SSD 6010 - One Residential Building (Student Accommodation) within Darling Drive Plot

Submission by:

21 July 2013

SHADOW DIAGRAMS: PERSPECTIVE, SHOWING THE PEAK, WINTER SOLSTICE

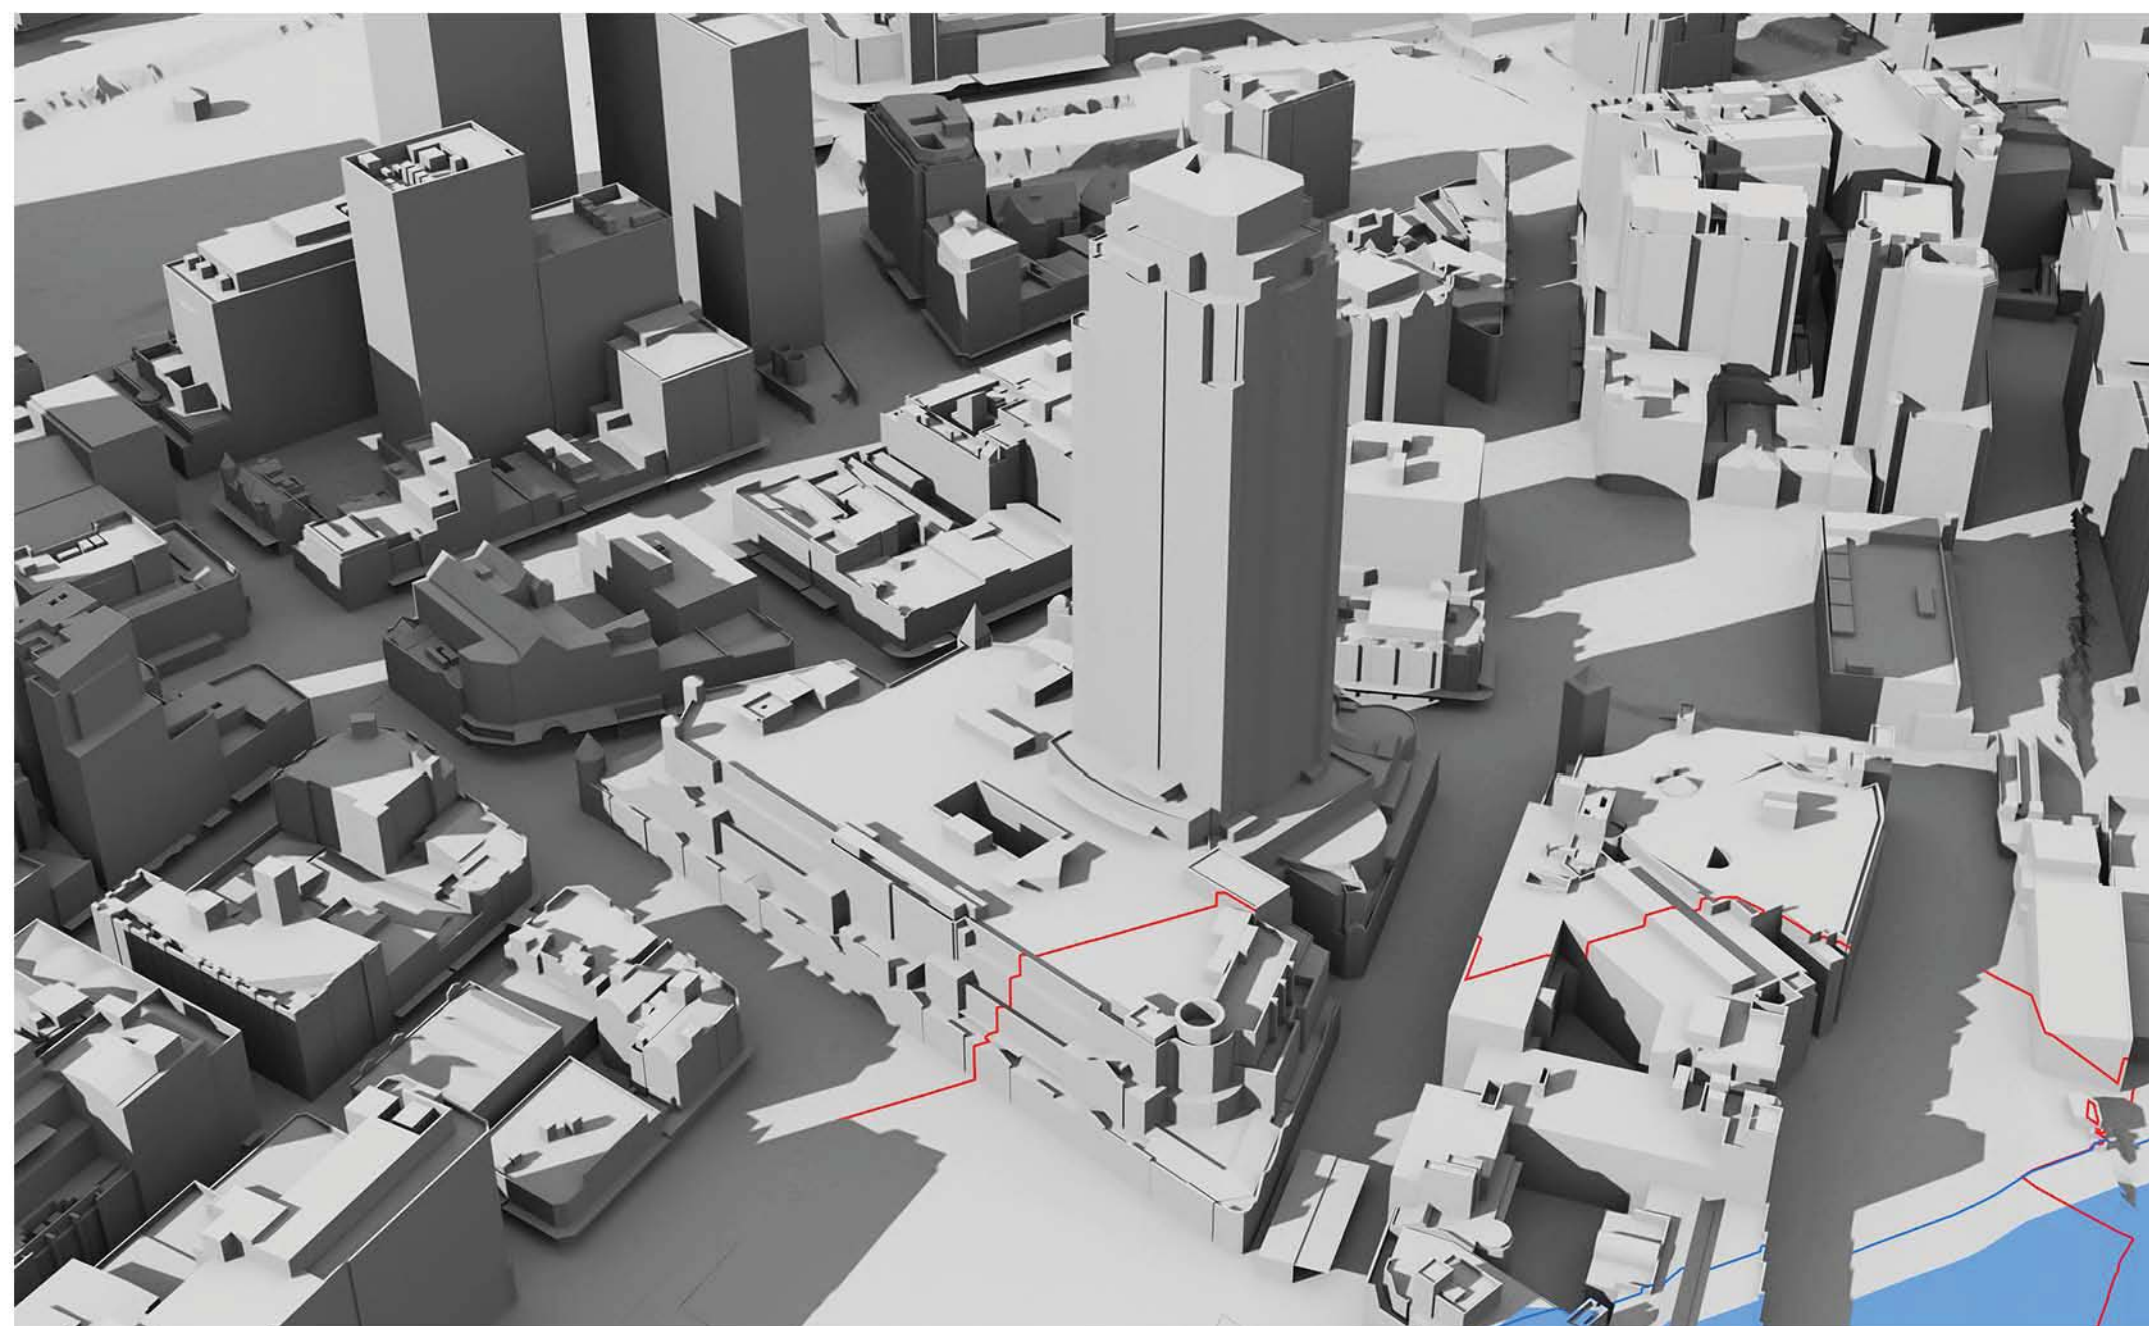
We refer to the shadow diagrams in SSD5878, Appendix H. Supplementary Design Report, Section 6. Amendments, Winter solstice - 22 June. This is not 21 June, but there would be no noticeable difference.

The south façade is not shown. On 21 June it would never receive any direct sunlight.

At 9am, 10am and 11am the west façade is totally in shadow due to other parts of The Peak building itself.

At 12pm there is still substantial existing shadowing on the west façade caused by the irregular shape of the west facade.

At 1pm the existing shadowing has been substantially removed, but not totally removed.

It can be concluded that some single aspect apartments on the west façade and some south-west dual aspect corner apartments currently receive less than 2 hours direct sunlight to habitable rooms and 50% of the private open space between 9am and 3pm on 21 June.

By 2pm the existing shadowing has been totally removed, but that is too late to achieve two hours of direct sunlight before 3pm.

At 9am, 10am and 11am the west façade is totally in shadow due to other parts of The Peak building itself.

At 12pm there is still substantial existing shadowing on the west façade caused by the irregular shape of the west facade.

At 1pm the existing shadowing has been substantially, although not entirely, removed. However, overshadowing of lower levels of the west façade by the concept proposal parameter plan shadows for the N,NE and SE plots has already started.

By 2pm the existing shadowing has been totally removed. However, overshadowing of the west façade by the SSDA4 and SSDA5 buildings has appeared and risen further up the west façade than the concept proposal parameter plan shadows for the N,NE and SE plots, which is still present.

At 3pm, the proponent states correctly that 45-45% of the western façade is overshadowed by the SSDA4 and SSDA5 buildings.

It can be concluded that, as a result of combination of the proposed development with existing shadowing of the west façade, some single aspect apartments on the west façade and the south-west dual aspect corner apartments which currently receive less than 2 hours direct sunlight to habitable rooms and 50% of the private open space between 9am and 3pm on 21 June will suffer additional overshadowing. It is beyond our skills to count the number of such apartments. We note that the proponent has made no attempt to do so.

Rather than counting the number of units which will not meet the DCP guidelines, the proponent attempts to trade-off direct sunlight at 4pm for lack of direct sunlight during the period 9am to 3pm. There is no provision in the DCP guidelines for such a trade-off.
